Our Ref: DA S29/3/97-MOD-1

**Eastern Creek Karts (DA S29/3/97)
Section 4.55(2) Modification for Earthworks and Drainage (MOD 1)**

Thank you for civil works, drainage and landscape information prepared by Martens & Associates and Conzept Landscaping Design and received by the Department on 30 July 2021. The Department's assessment of this recent response to its Request for Information (RFI) raised some design and safety matters to be resolved prior to further consideration.

TITLE:
SITE PLAN

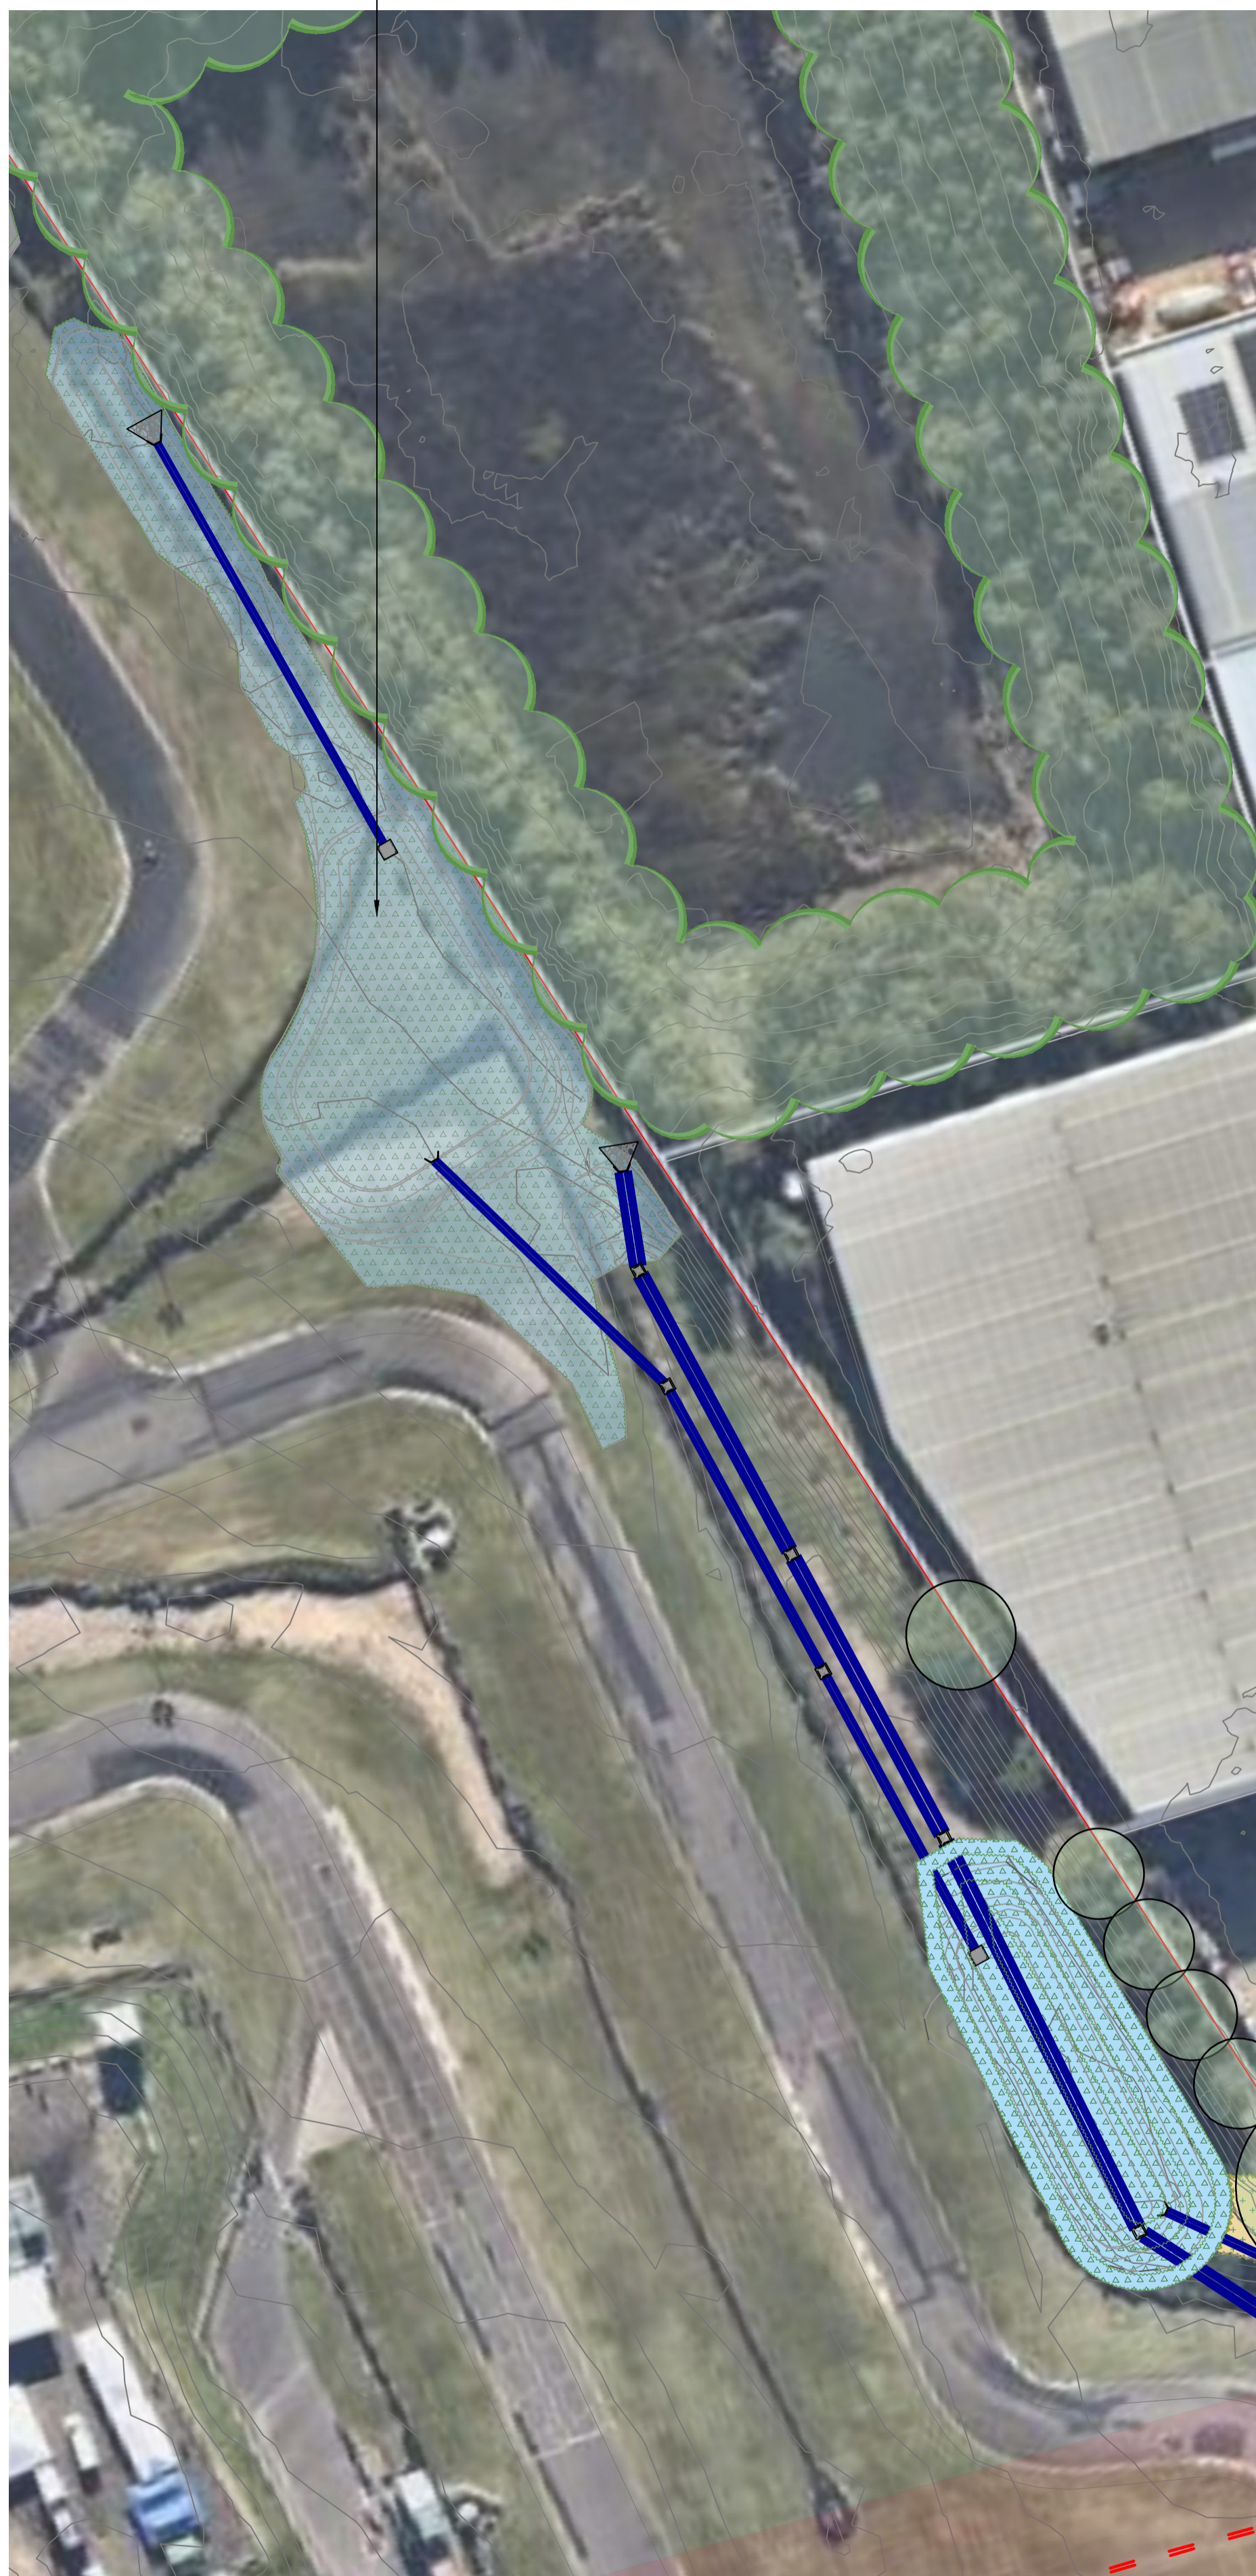
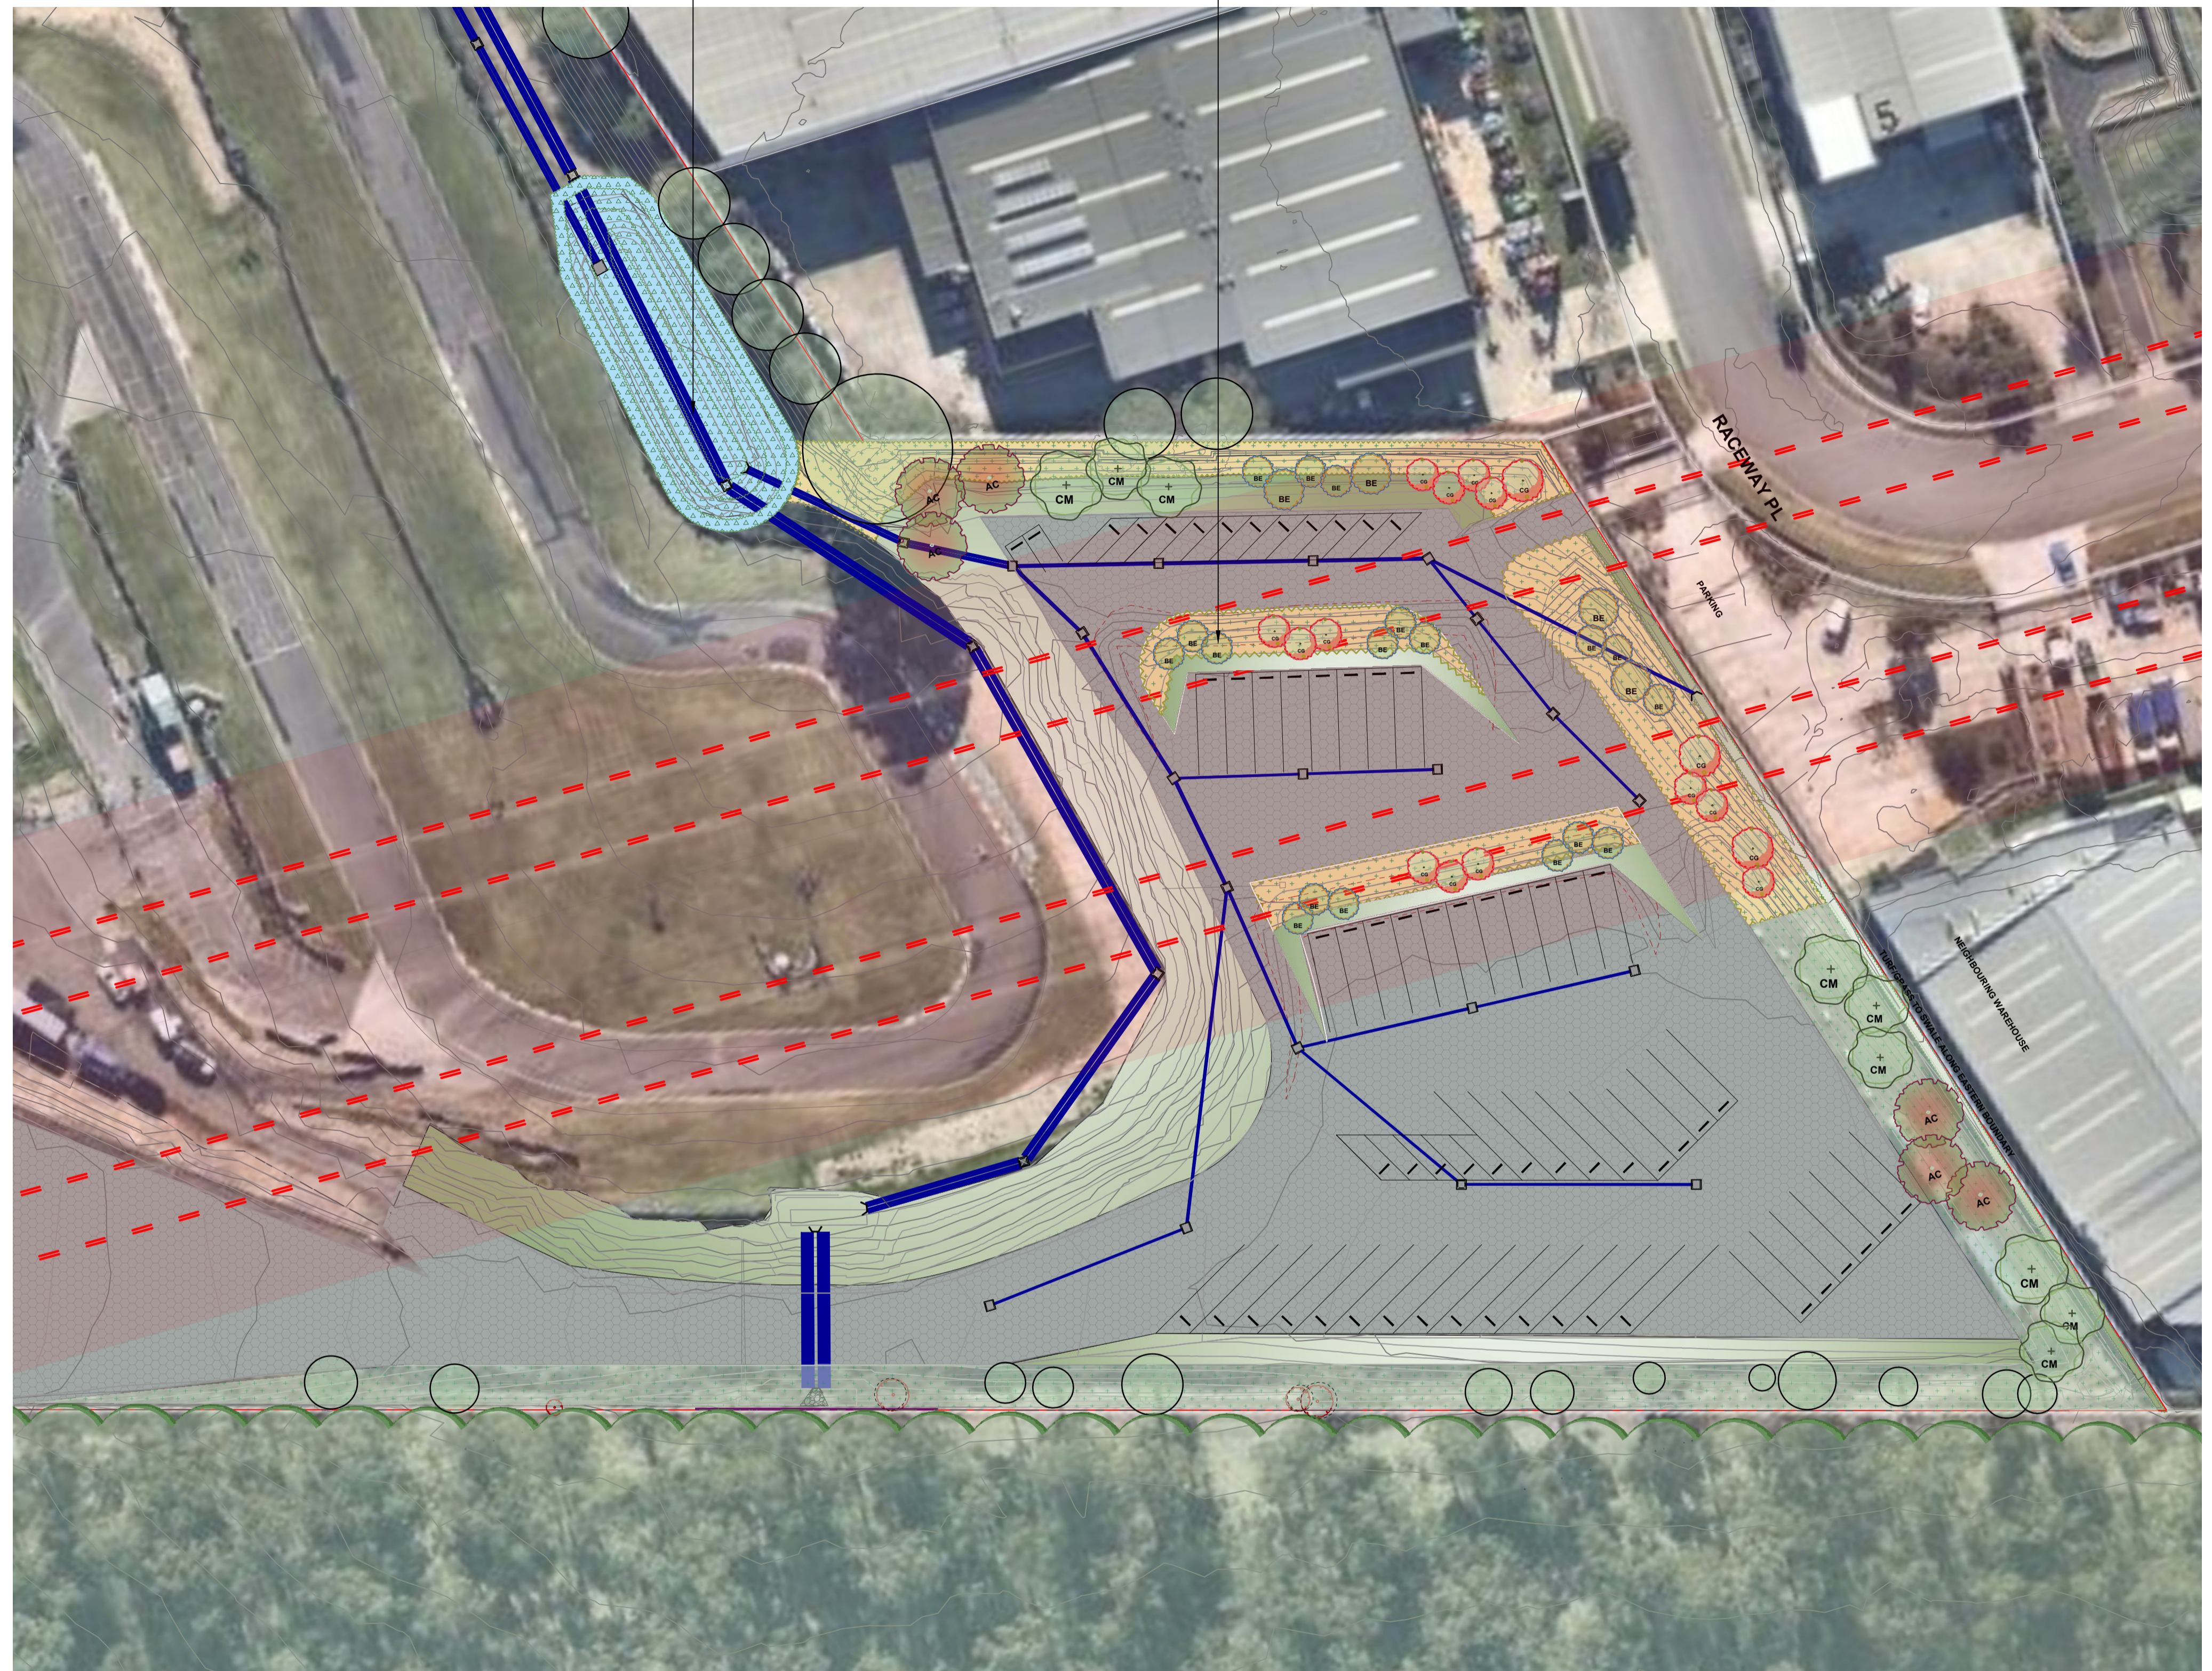
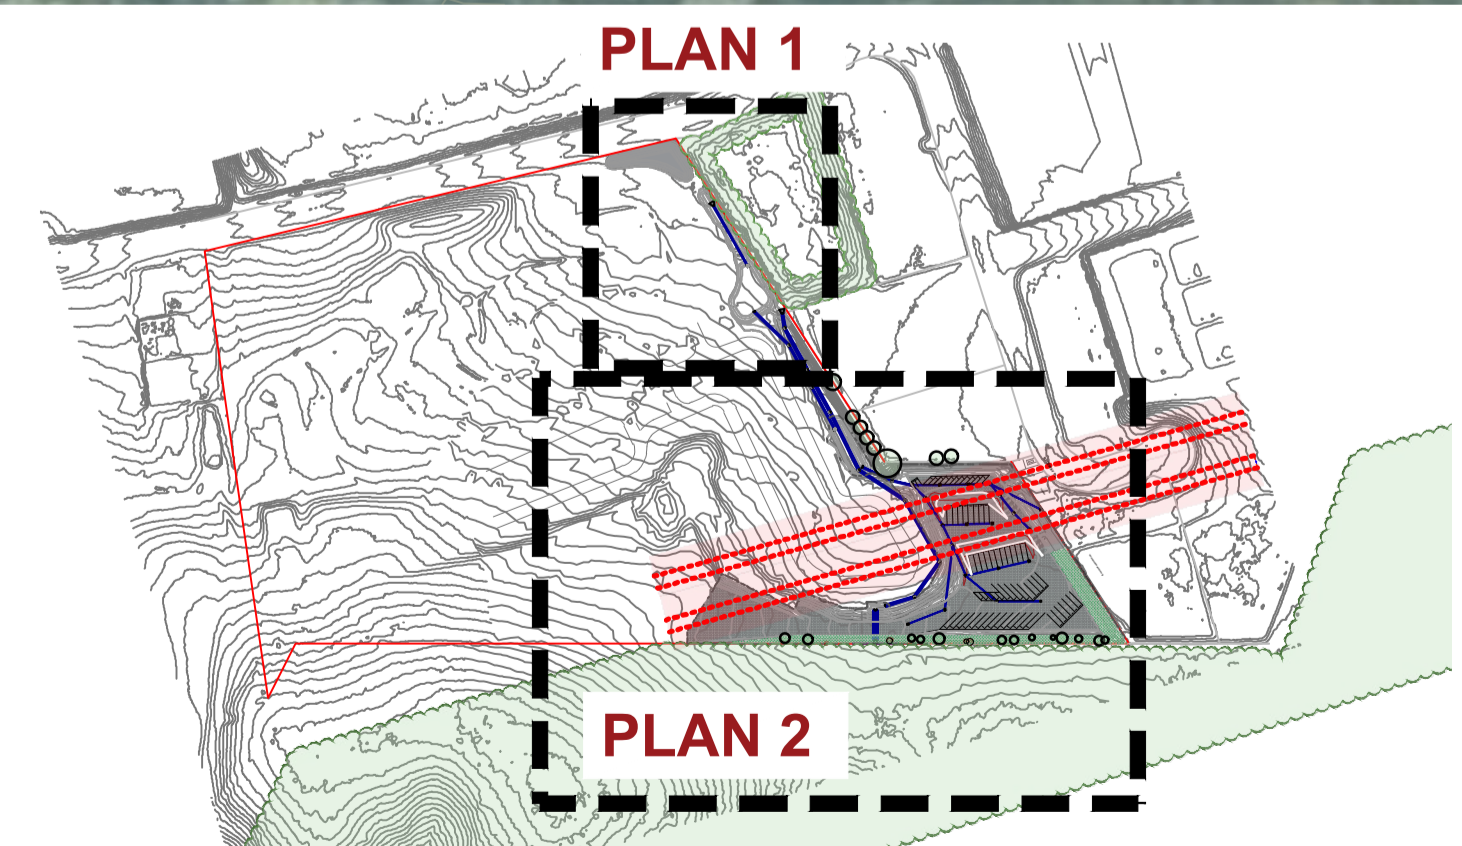
Landscaping Plan LPS4.55 - 22/31 by Conzept Landscape Architects is noted. Concern is raised for the planting of tall canopy species *Angophora costata* and *Corymbia maculata* in areas :

- near proposed pipe drainage, or
- on steep batters and retaining wall systems that may not have anticipated all design load surcharges.

It is requested the Engineer and Landscape Architect confirm suitable locations for the canopy species where mature tree growth would not impact the service life of drainage pipes, and the Engineer provide assurance for the structural capacity and safety of the proposed batter and retaining wall systems given the canopy trees' anticipated surcharge loadings.

Should any planting be reconsidered due to drainage or structural capacity concerns, please provide a revised planting design prepared by the Landscape Architect and supported by the Engineer in writing, to address matters of visual impact raised by the Department in the RFI letter of 13 May 2021 Appendix 1 Section 6.
